# CITY OF ALBUQUERQUE

July 11, 2024

**Re: Thomas Development- Final Submittal  
Traffic Impact Analysis (C08D002)**  
Study dated June 10, 2024  
Via email cvermillion@bhinc.com

PROPOSED ACCESS MANAGEMENT CONCEPT

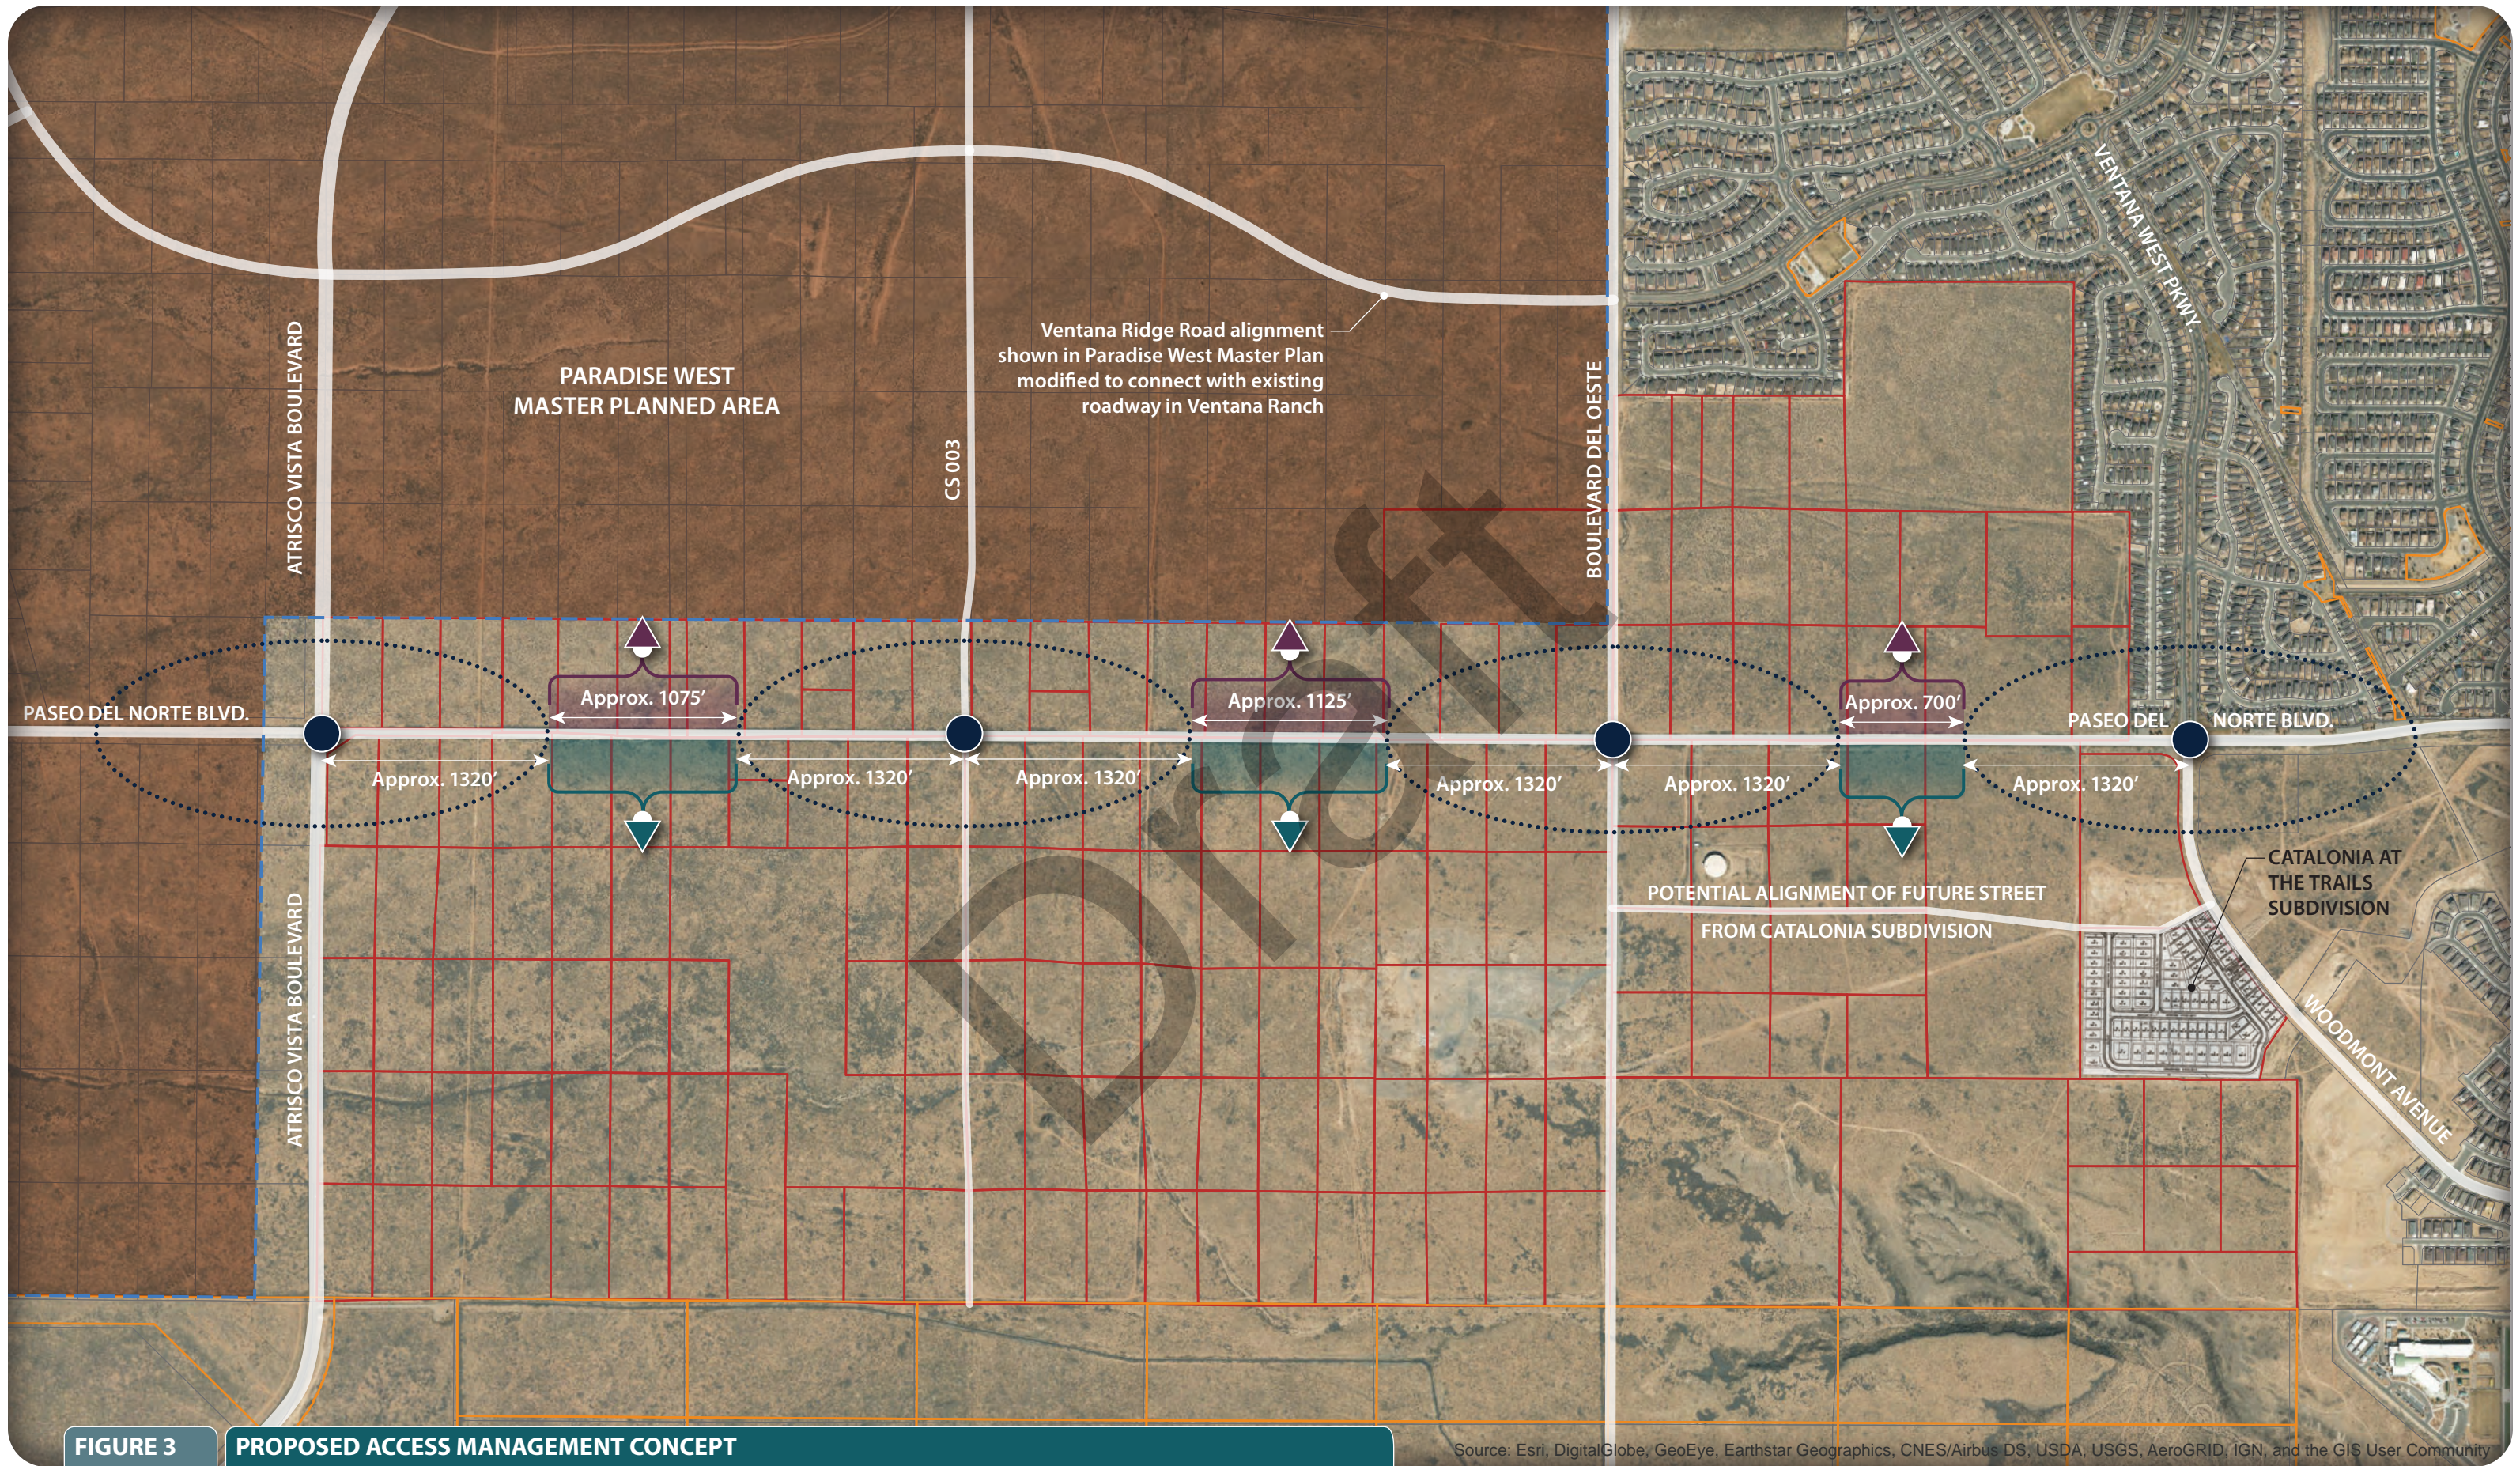
- b. The proposed right-in/right out driveway on Paseo Del Norte in the location shown is not in RAC Inventory of Roadway Access Limitations Attachment #1 dated 12-1-23.

- c. In addition, a right-in/right out won't work without a median.
  - d. Thank you for providing the Paseo Del Norte Access Management Plan mentioned in the study. This plan was developed for Bernalillo County and is a DRAFT, so it has little status. This should be clear in the Study as it is currently written as if it is a City/MRCOG approved document.
